From: Neil Crowther <Neil.Crowther@arun.gov.uk>
Sent: 30 July 2021 13:41
To: Planning.Responses <Planning.Responses@arun.gov.uk>
Subject: FW: Planning app number CM/17/21/PL Wren Cottage Climping.

From: Neil Crowther
Sent: 30 July 2021 13:41
To: Karen Almond [REDACTED]
Subject: RE: Planning app number CM/17/21/PL Wren Cottage Climping.

PLOT 1 ELEVATIONS
SCALE 1:100 @ a3

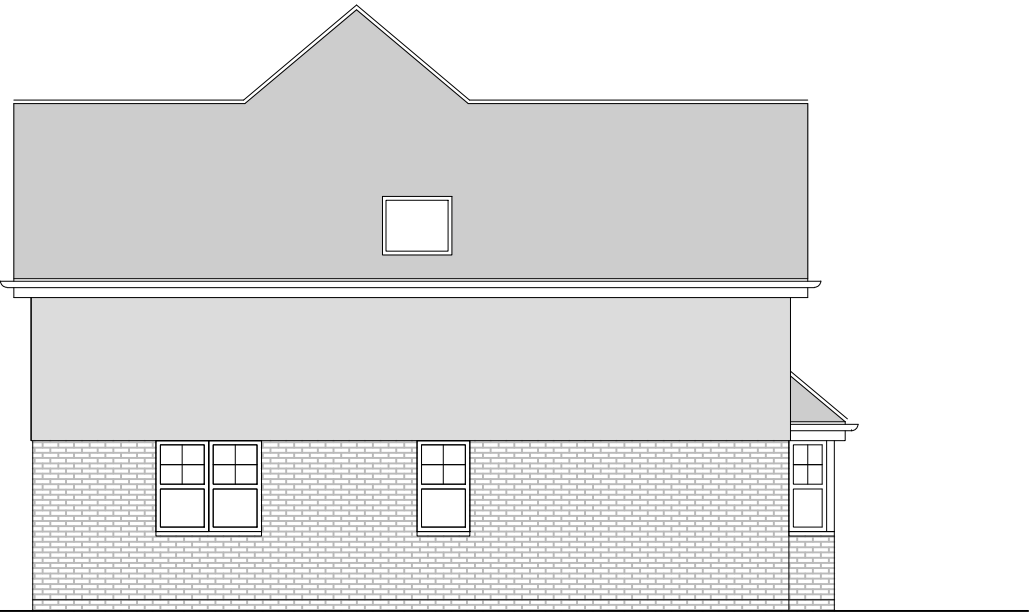
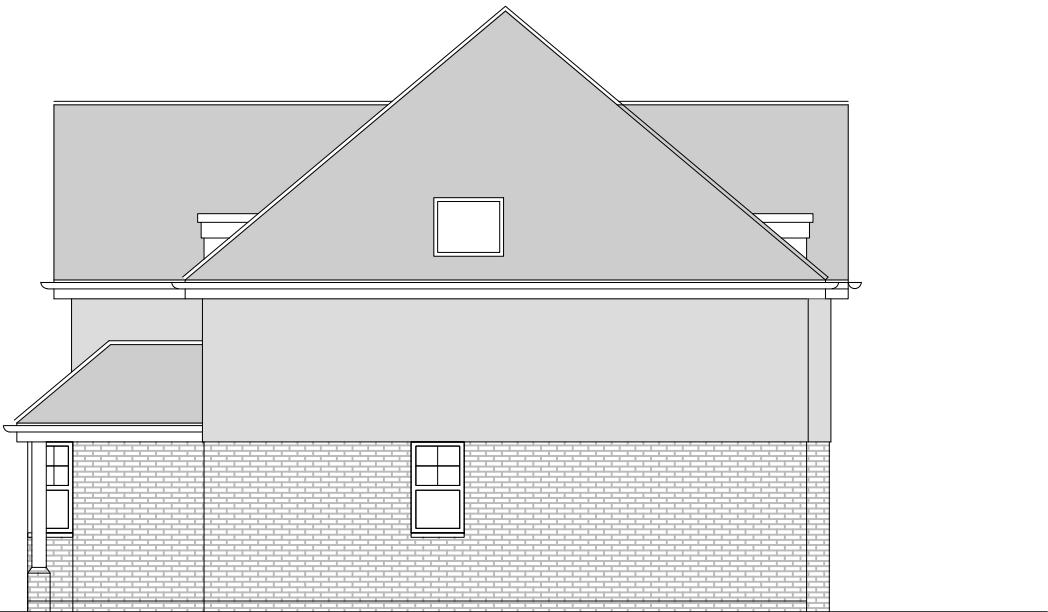
On the 15th July (substitute plan - site plan 504 02). Plot 1 and 3 are exactly the same distance apart from 4 and 6 Wooldridge Walk. So why have there been major alterations to plot 3 and not plot 1.

Would you kindly explain why my property has been completely ignored and that I am still left with a large 2 storey 3 bedroom house with 2 large bedroom windows facing west directly overlooking my garden and into my 2 bedrooms at the back of my property and invading my privacy it is just not on. Its as though I and my property don't exist and are not important enough.

My email dated 16 July explains why no changes were sought to plot 1 in terms of the size/scale of the unit. As I stated, we have requested that the dwelling is sited a minimum of 12m from the boundary to accord with our Design Guide.
